As requested, I attach the latest drainage maintenance plan addressing the risks identified by Laura.

Thank you for providing the details, I have the following comments:

Subject: RE: LU/330/18/PPL – Land at Cornfield Close, Littlehampton

Drawing No.	M637_15.004	Rev	T3
-------------	-------------	-----	----

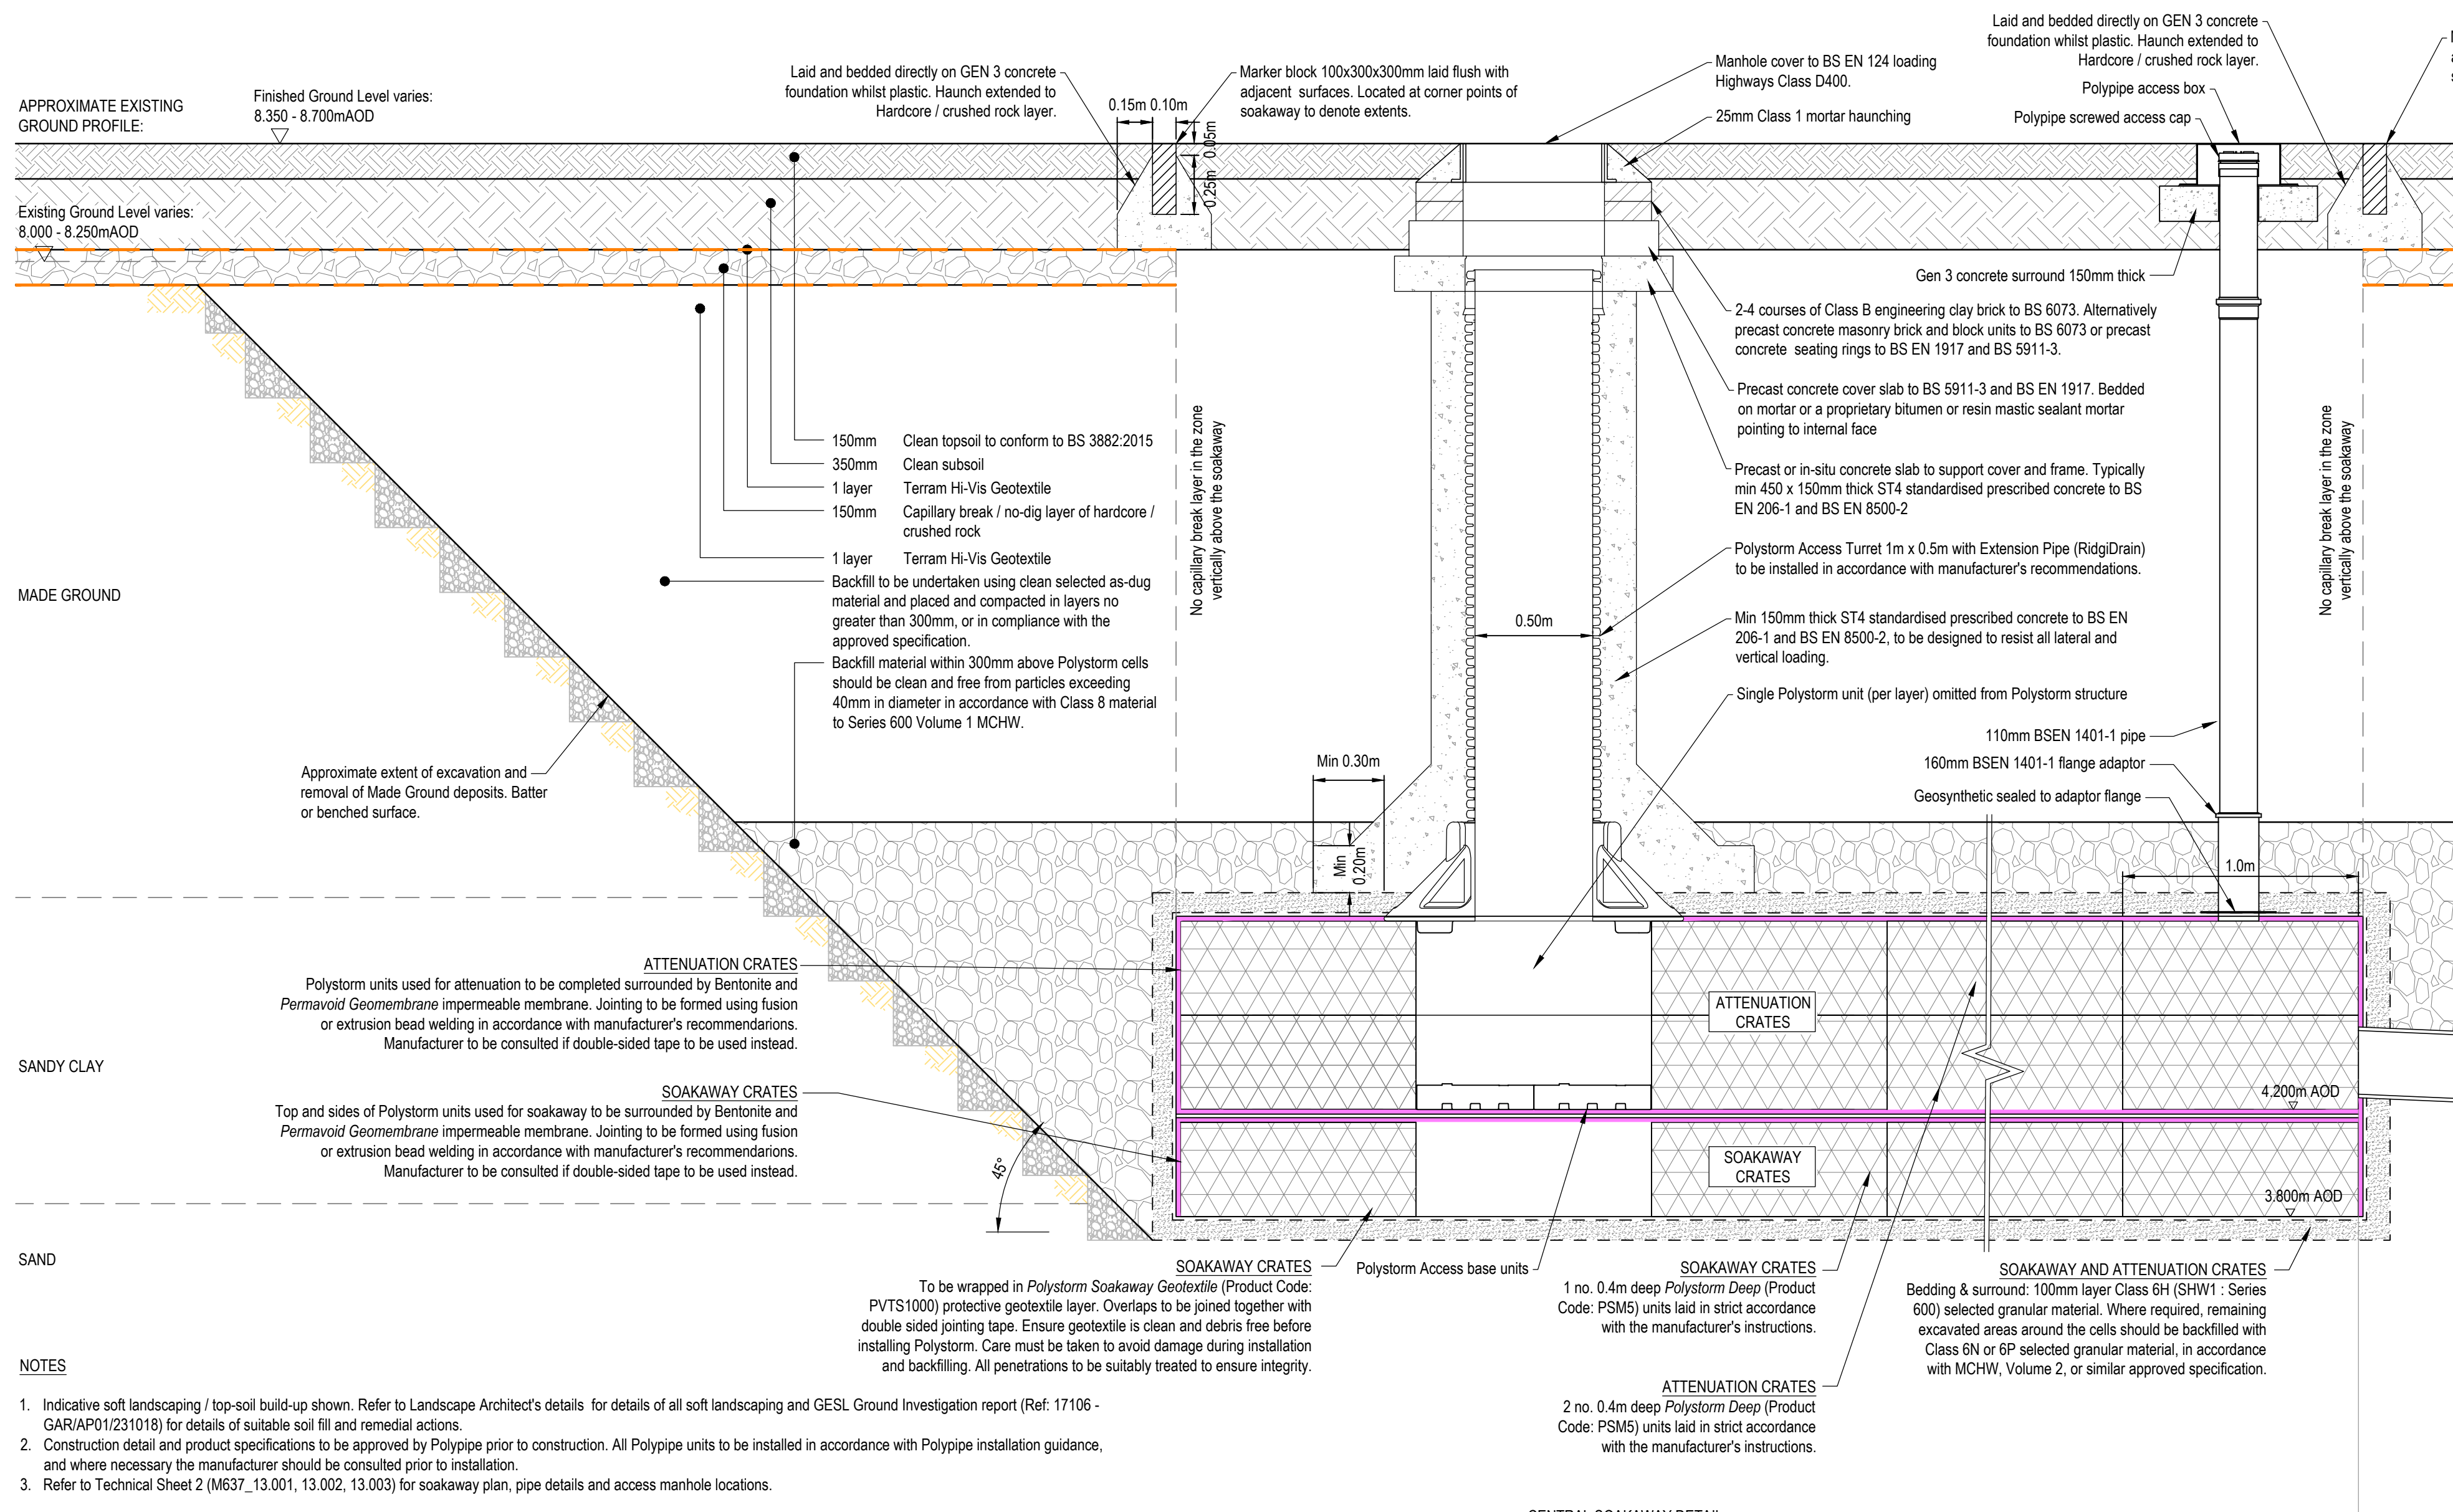
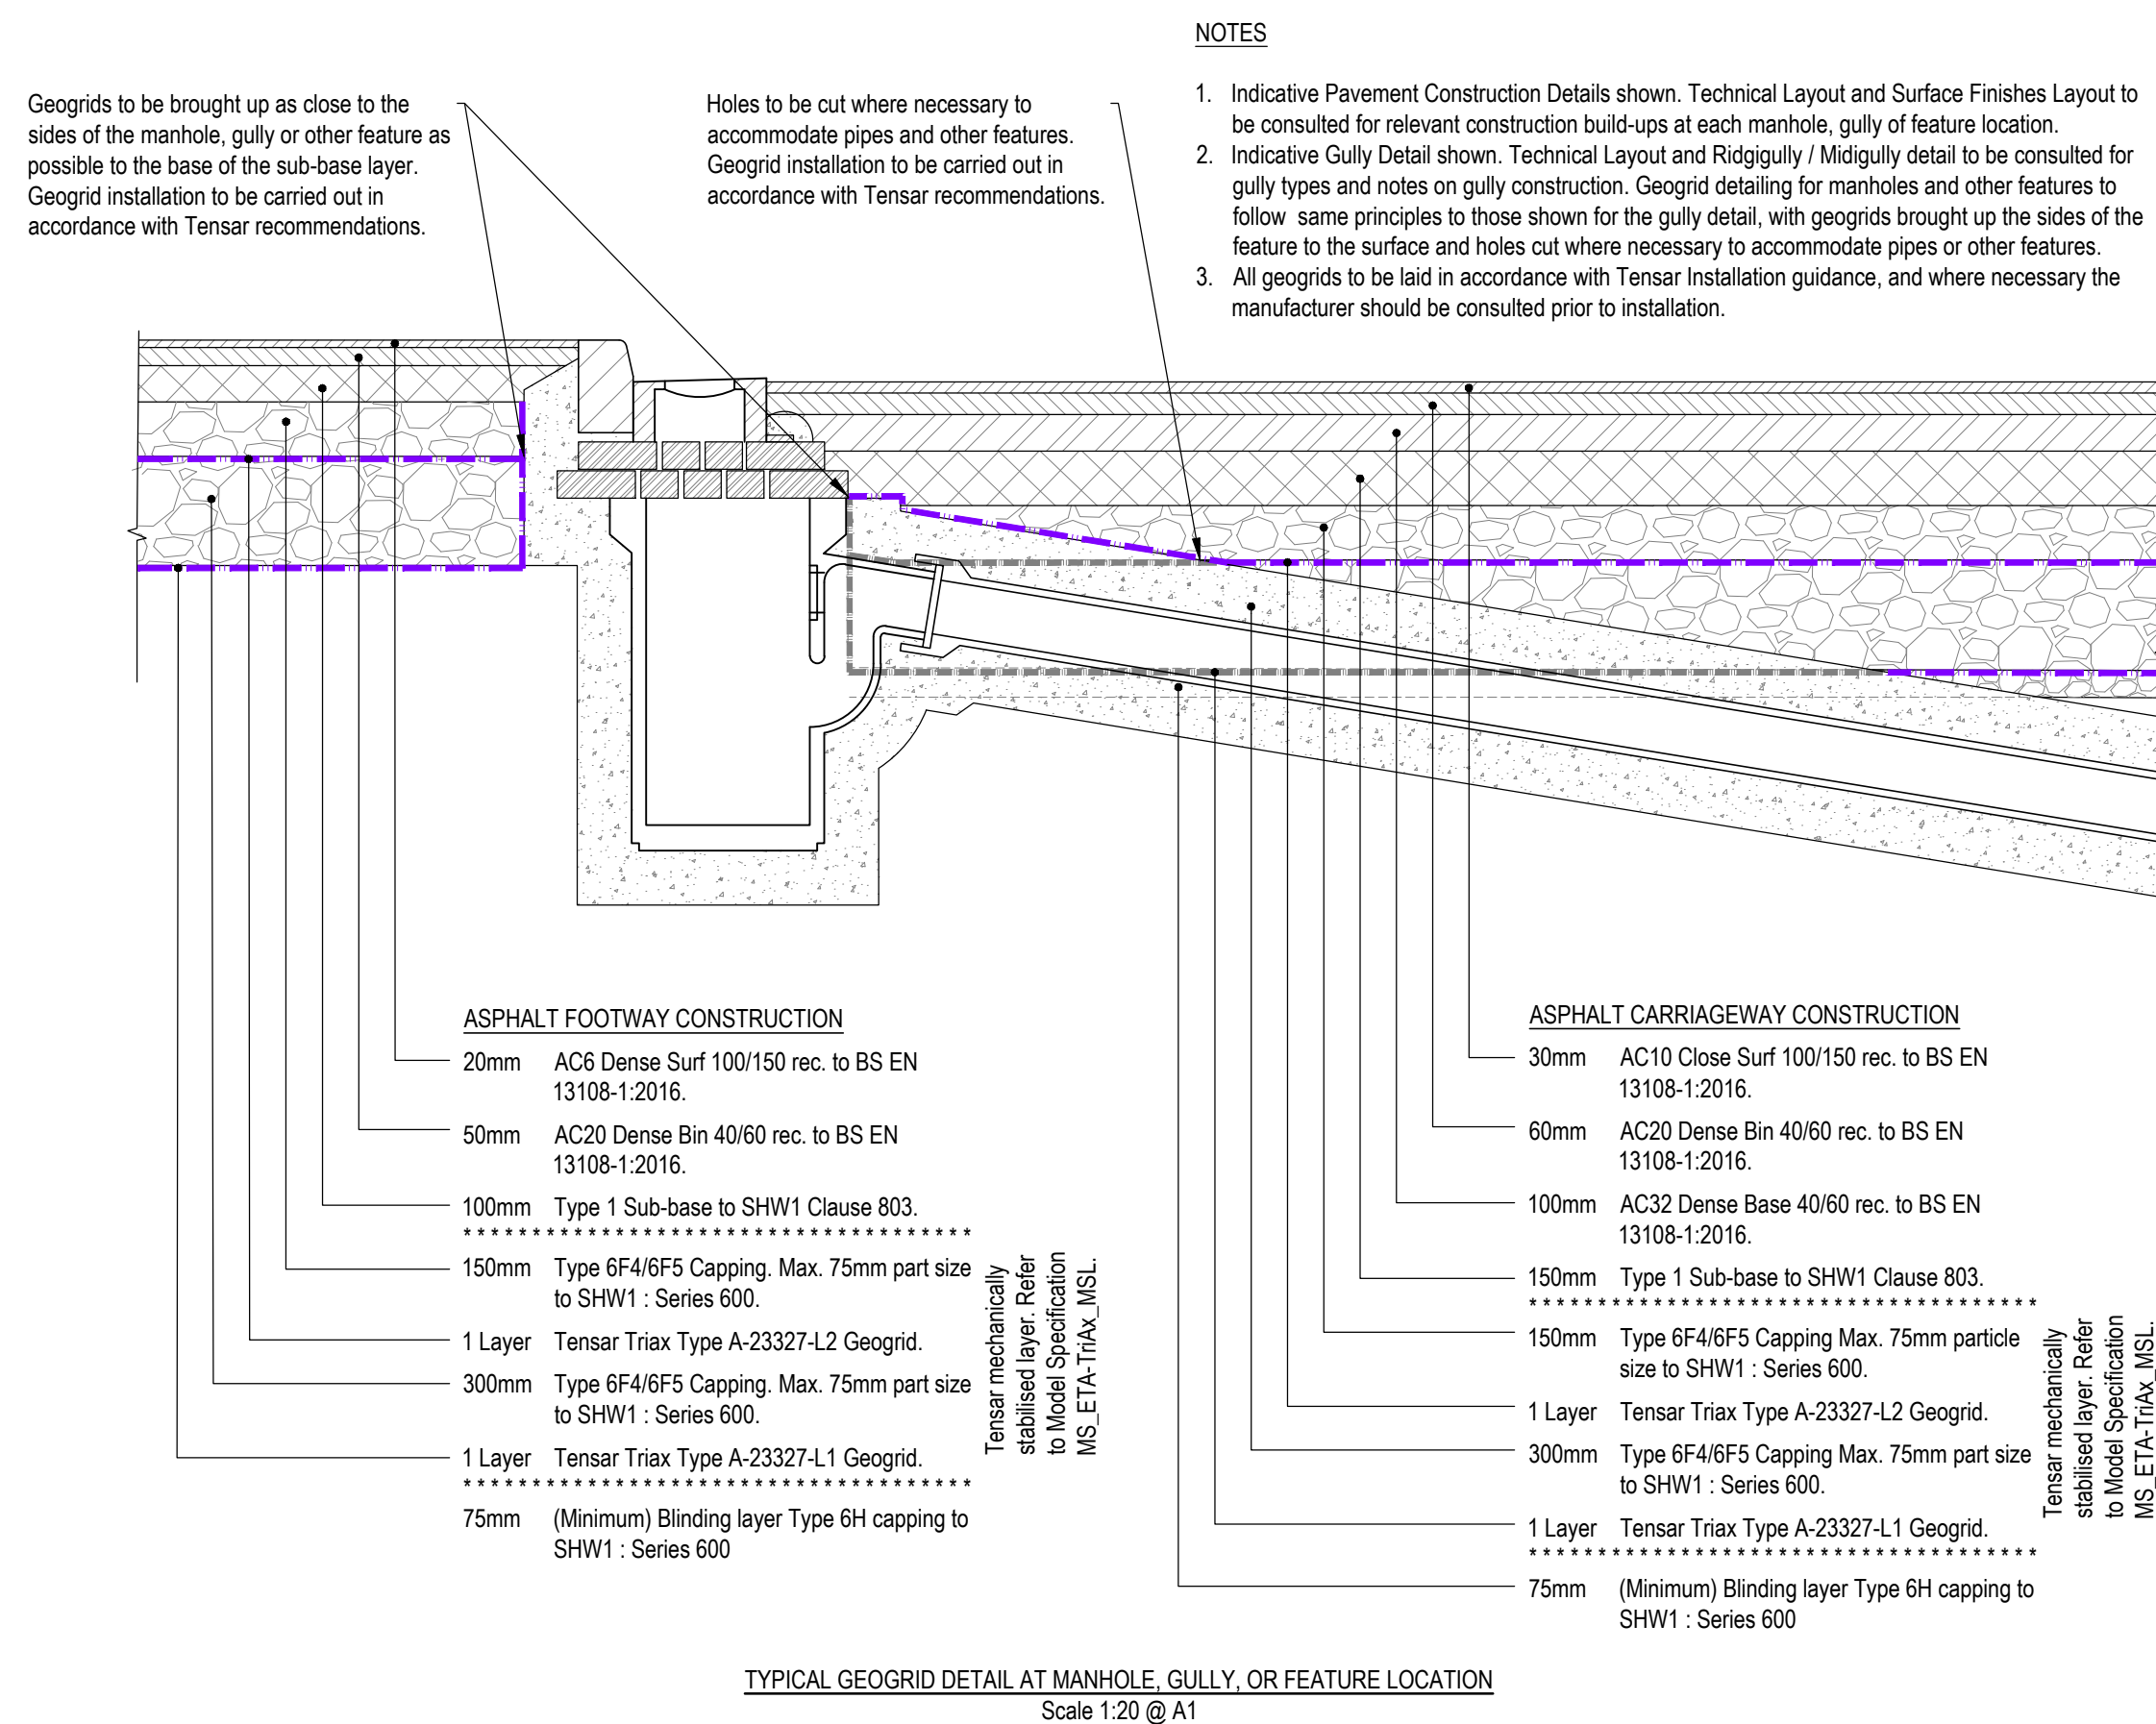
8. Please provide a construction detail drawing of the lower crate access.

This has been added to Drainage Details Sheet 2 M637_15.005. On review, please consider the safety of access/ maintenance and consider if a standard inspection chamber (no catchpit) could provide a means of maintenance for the majority of occasions without having to send a man down the inspection chamber.

Noted. Chamber S50 has been amended to remove the sump – updated drawings are attached.
